Project name	Little Crow Solar Park
File reference	EN010101
Status	Final
Author	The Planning Inspectorate
Date	23 April 2020
Meeting with	INRG SOLAR (Little Crow) Ltd
Venue	Teleconference
Meeting objectives	Project update and draft documents feedback discussion
Circulation	All attendees

Little Crow Solar park

Section 51 Advice –draft Application Document by INRG SOLAR (Little Crow) Ltd for review by the Planning Inspectorate

PUBLIC RIGHTS OF WAY PLAN
LITTLE CROW SOLAR PARK

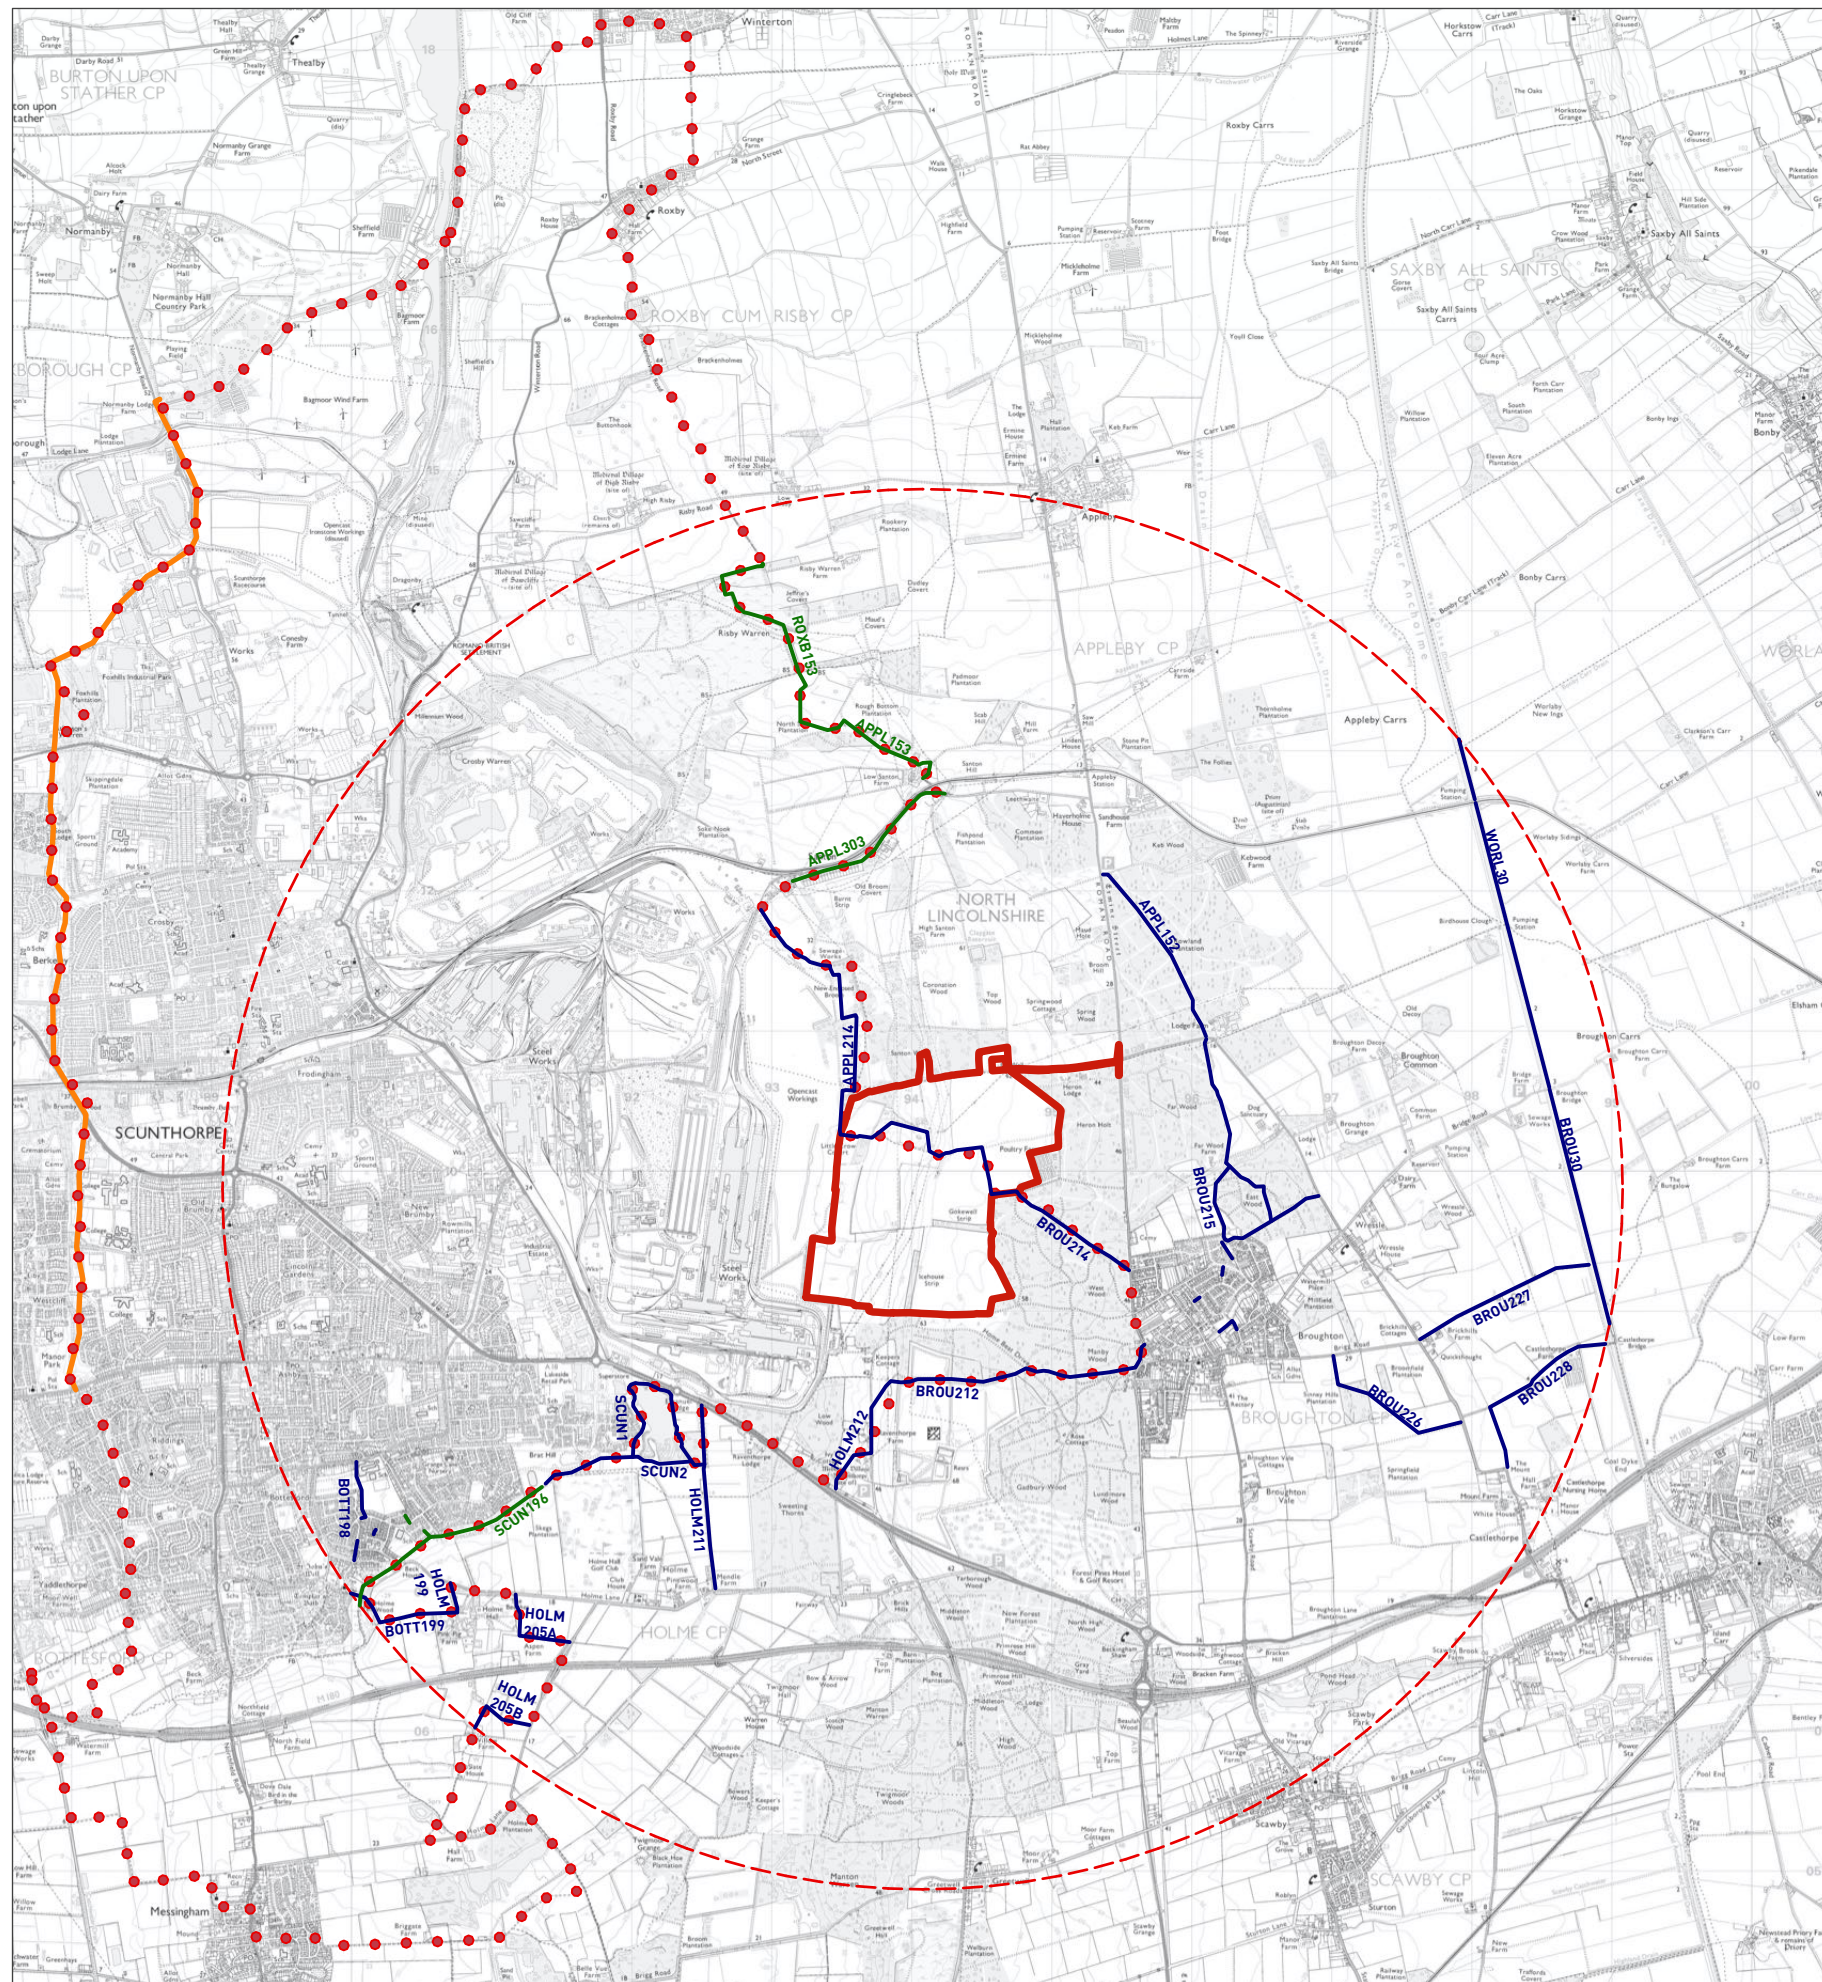
7.	Public Rights of Way Plans	<i>Existing Public Footpath</i>	Unclear whether this means Existing Public Footpath to be stopped up or to be retained?
